Application No: BR/190/20/OUT
Site Address: 26 Burnham Avenue Bognor Regis PO21 2JU
Description of works: Outline application with all matters reserved for 10 No. new dwellings consisting of 1 No. 1 bed property, 8 No. 2 bed properties & 1 No. 4 bed property with associated services, landscaping, car parking & amenity (resubmission following BR/49/19/OUT).

Thank you for your internet representation made on 28th September 2020 which has been recorded as an objection with the comments as follows:

SITE PLAN (PROPOSED) 1:200

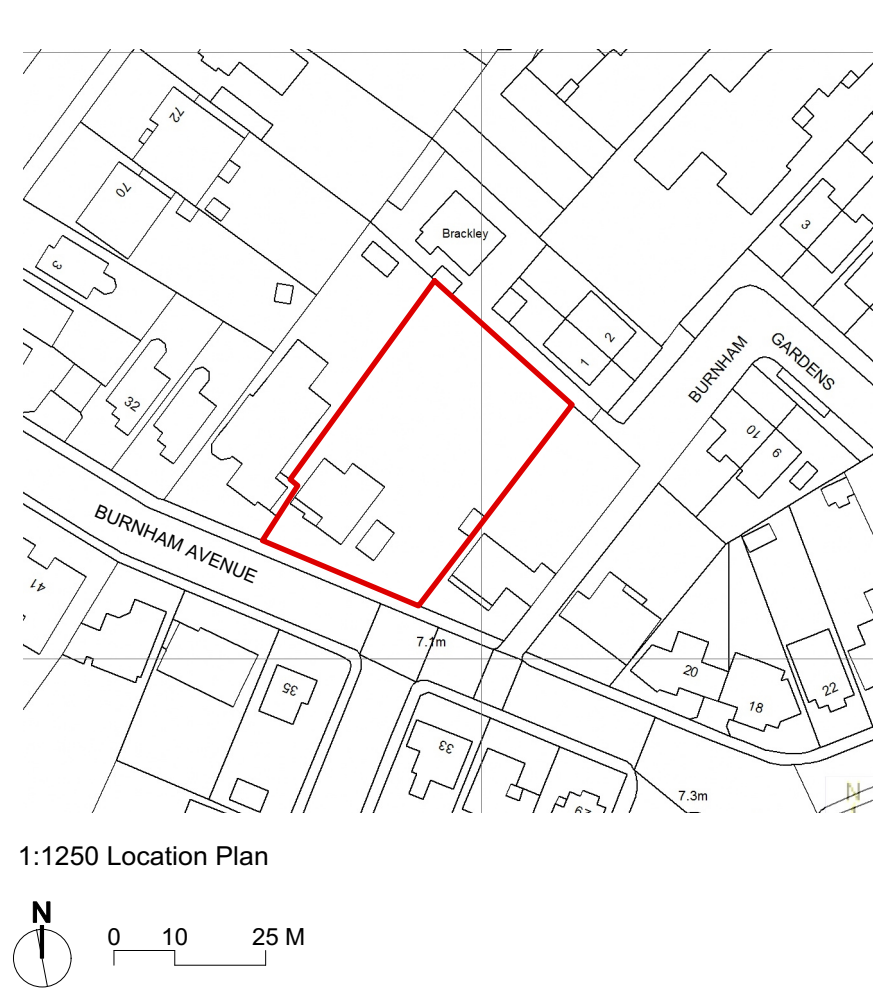
While there is a parking provision for the flats I do not think it is adequate. For example, we are a two-person household and we have two cars, therefore, it is probably safe to assume that there will probably be two or more car for each flat. If more than two people live in each flat this may be more.

This could have an impact on the on street parking, particularly as the plans show there will be two entrances to the site, one for the flats and one for the house, this will in turn take away additional street parking. I am also aware that several households in the vicinity have three or more vehicles.

Where will visitors park their cars?

STREETSCAPE - SOUTH ELEVATION (PROPOSED) 1:100

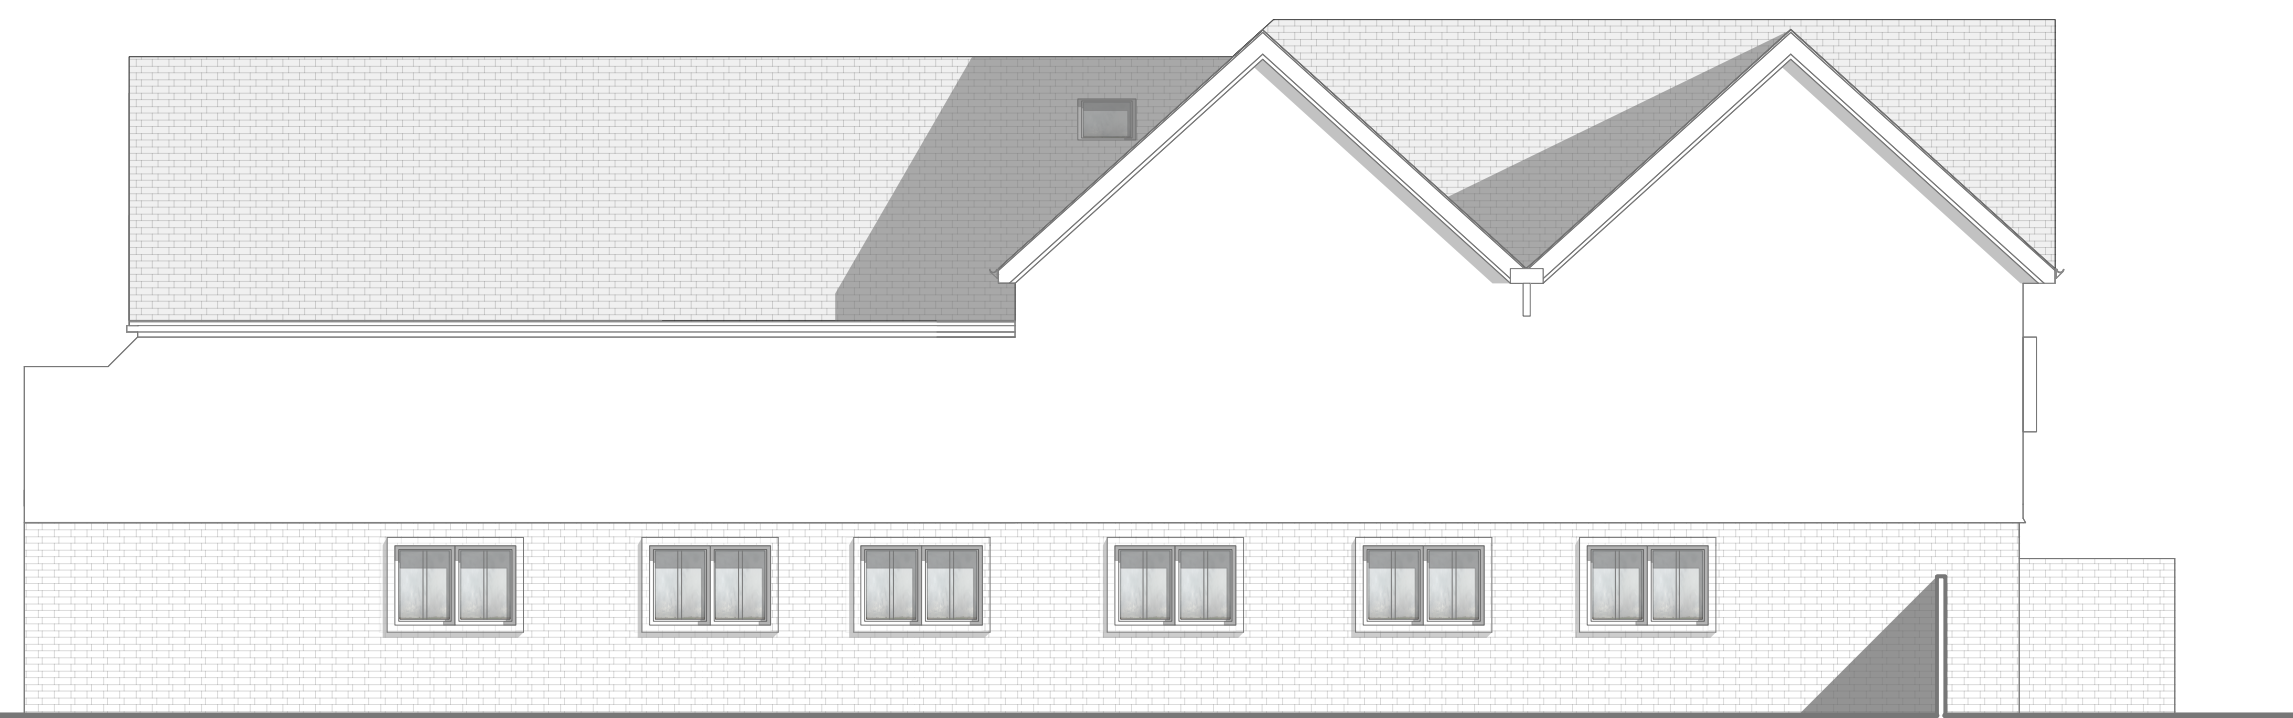
While I understand that the building will observe the existing building line and ridge height why do the flats have to be three stories high? This in my view is out of character with existing housing and could lead to some houses being overlooked.
